Application for a non-material amendment following a grant of planning permission.

Erection of Detached House with Detached Garage	
Reference number:	H19-0083-15
Date of decision	06/02/2015

Enlargement of proposed garage to move the staircase internally and provide additional welfare facilities for staff, including a shower and utility space.
Addition of a sun lounge to the rear of the dwelling complete with additional roof lights.

PROPOSED FIRST FLOOR PLAN Scale 1:50

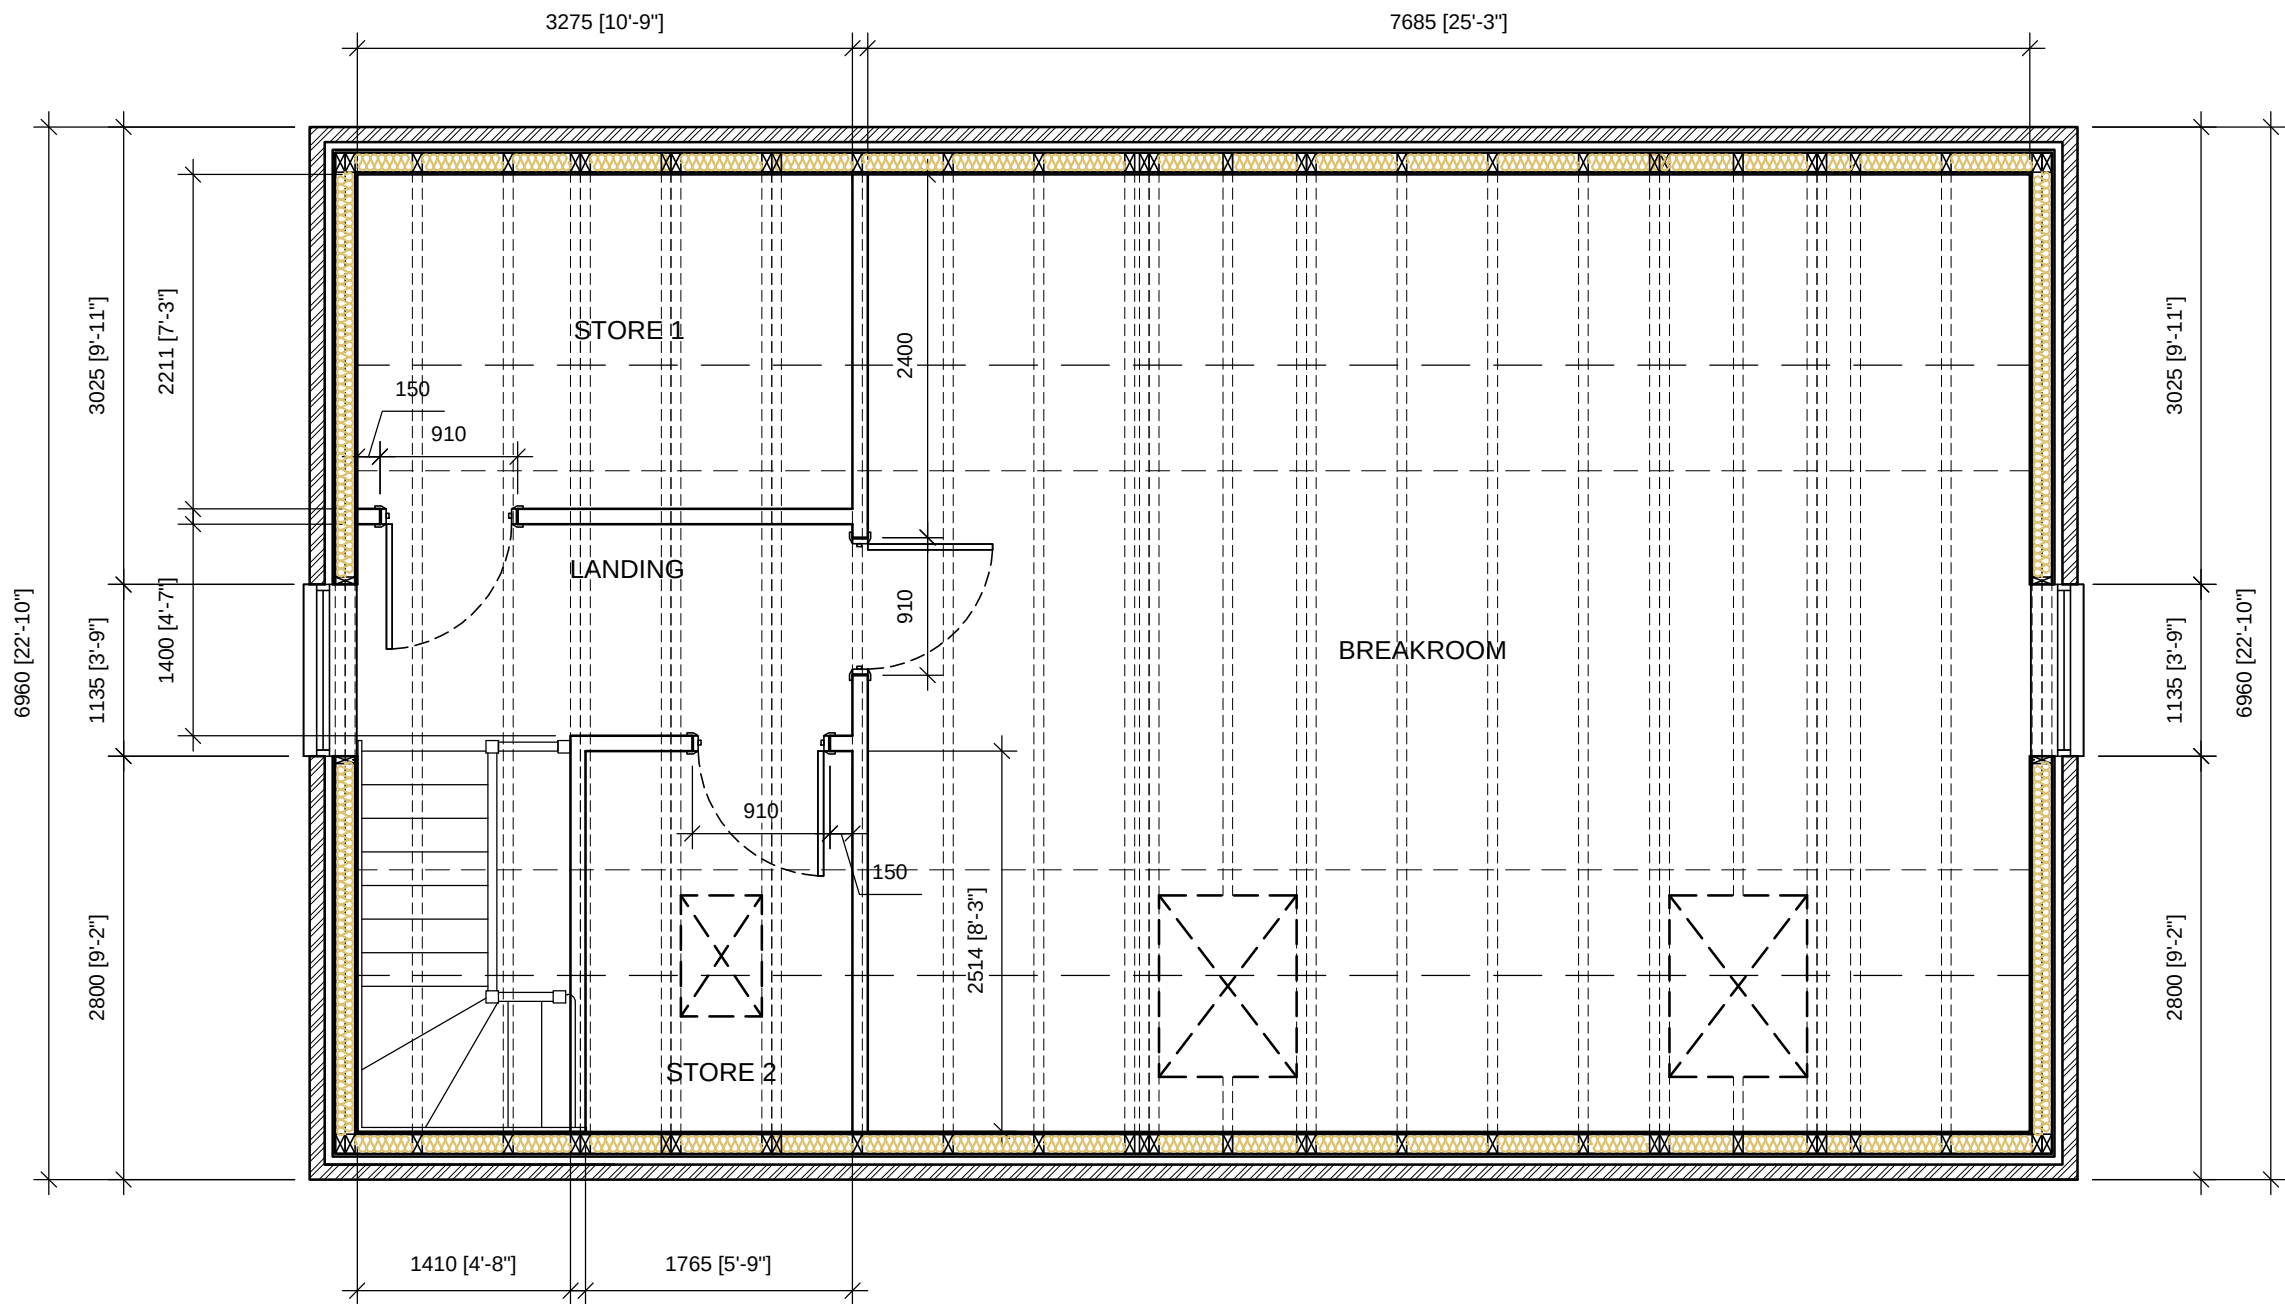
Due to the expansion of the business and additional workload a large breakroom is required together with additional parts storage and welfare facilities.
The sun lounge has been added to enhance the ground floor space. Roof lights have been added to naturally light the internal staircase and rooms.
